PRELIMINARY SITE GRADING CONSTRUCTION PLANS  
FOR  
**CREEKSIDE SOUTH AT LORSON RANCH**  
EARLY OVERLOT GRADING / EROSION CONTROL PLANS

**COVER SHEET**  
**EARLY GRADING AND**  
**EROSION CONTROL PLAN**

DATE: **MAY 12, 2020**  
PROJECT NO. **100.051**  
SHEET NUMBER **C0.1**  
TOTAL SHEETS: 15

SHEET NUMBER  
**C0.1**  
TOTAL SHEETS: 15

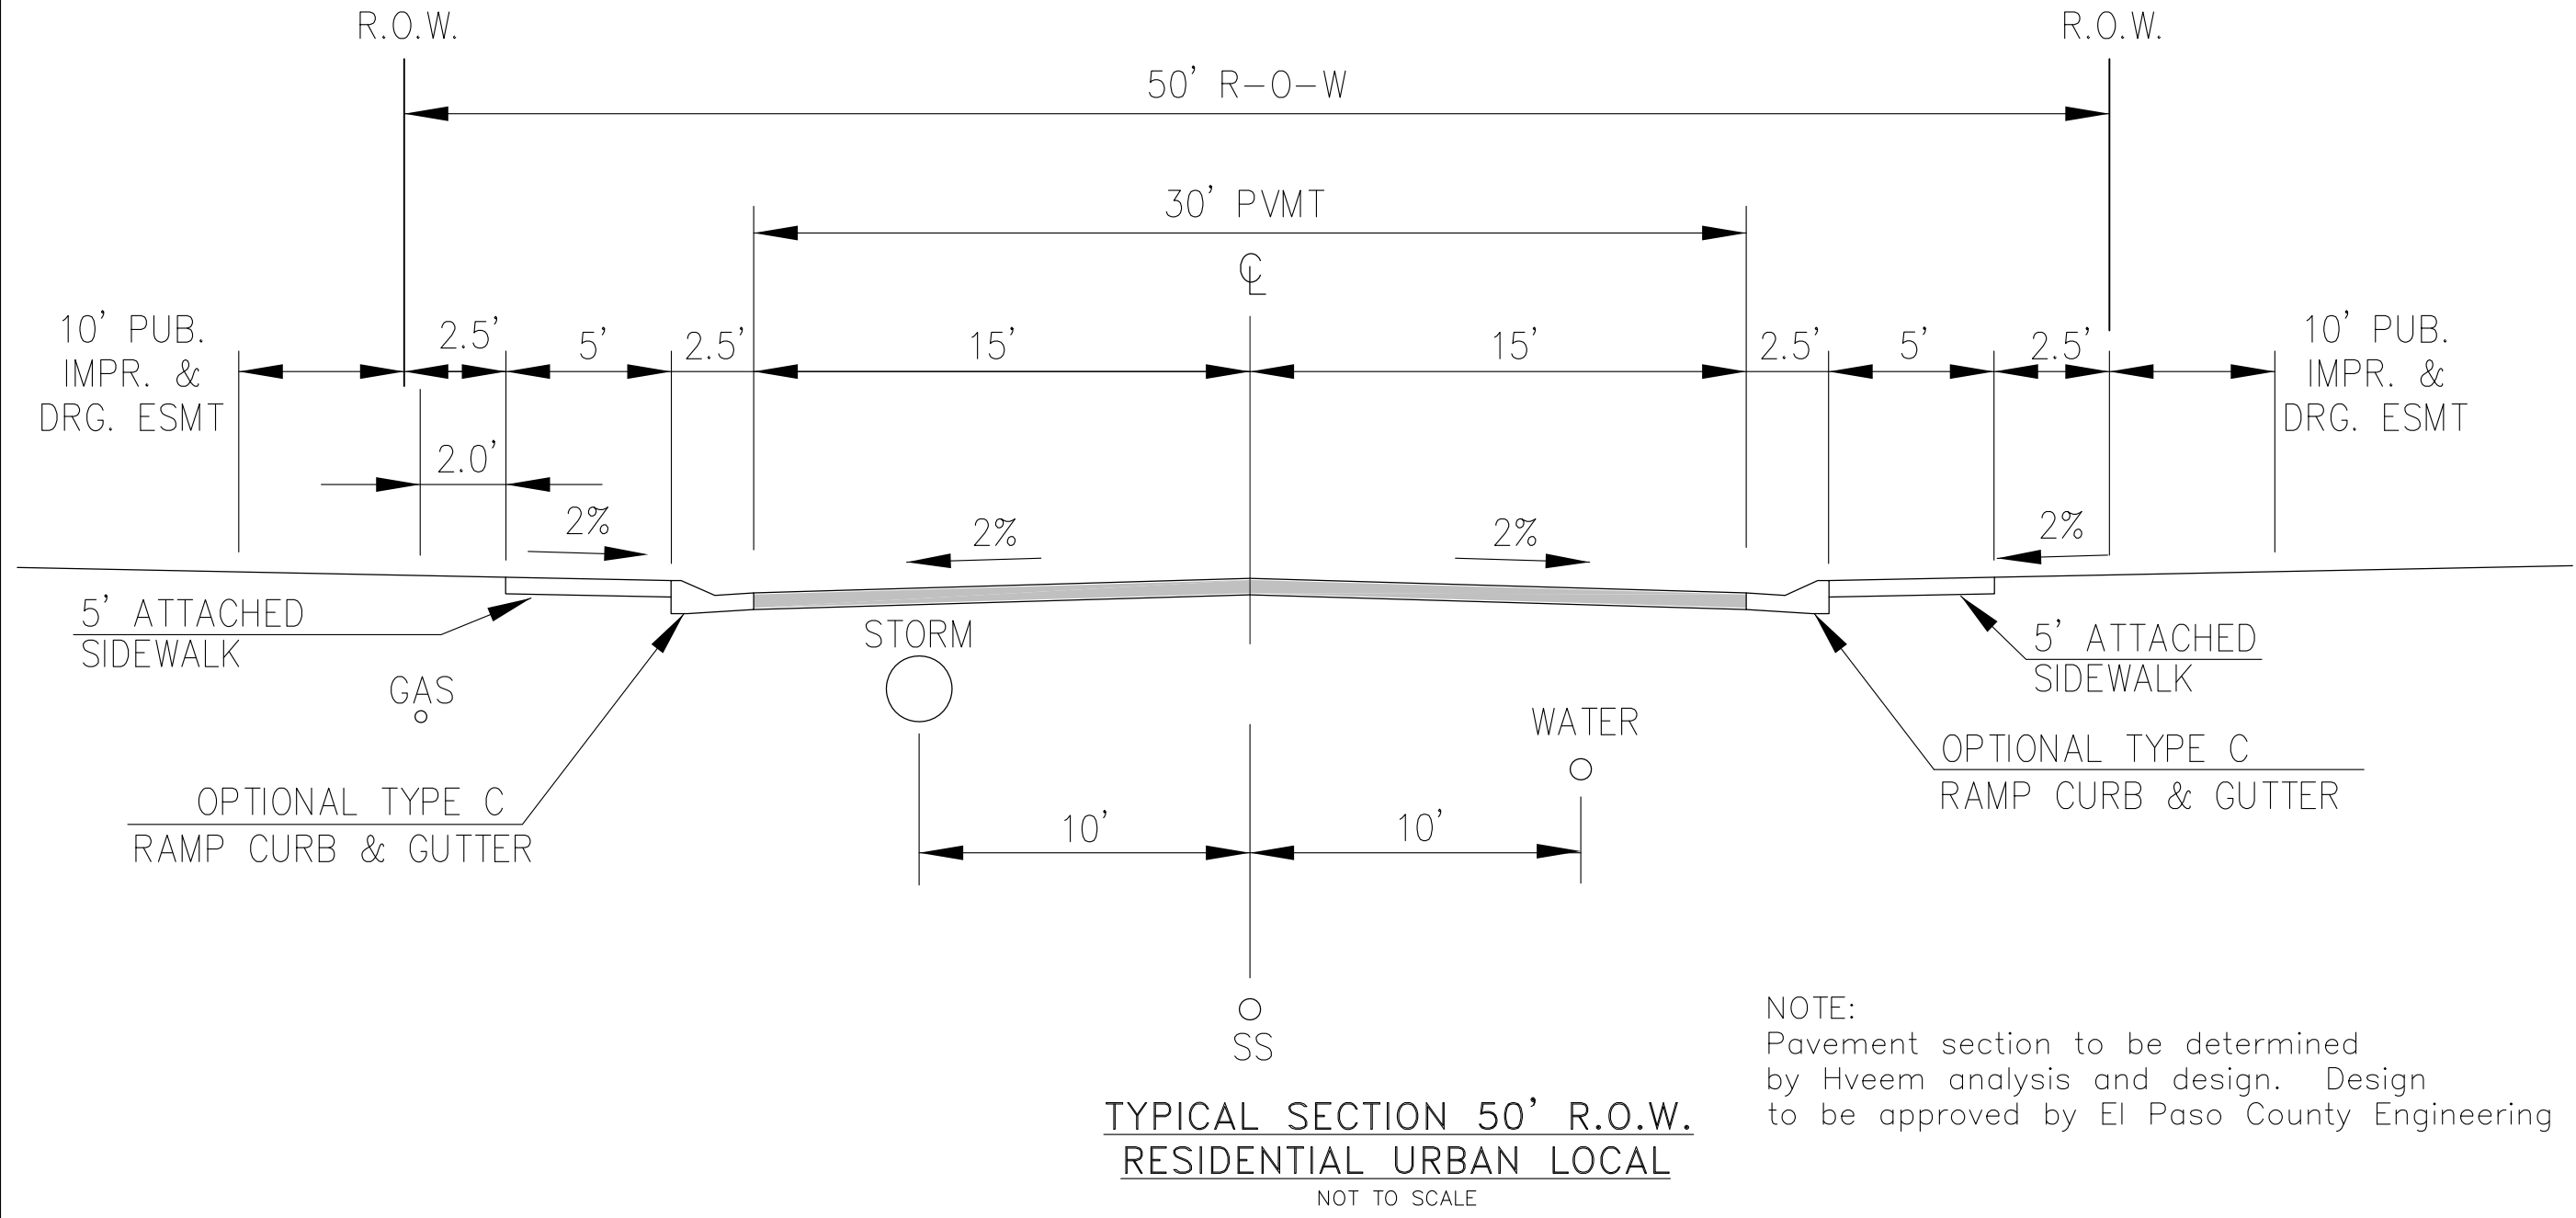
Update to state the following:  
County plan review is provided only for general conformance with County Design Criteria. The County is not responsible for the accuracy and adequacy of the design, dimensions, and/or elevations which shall be confirmed at the job site. The County through the approval of this document assumes no responsibility for completeness and/or accuracy of this document.
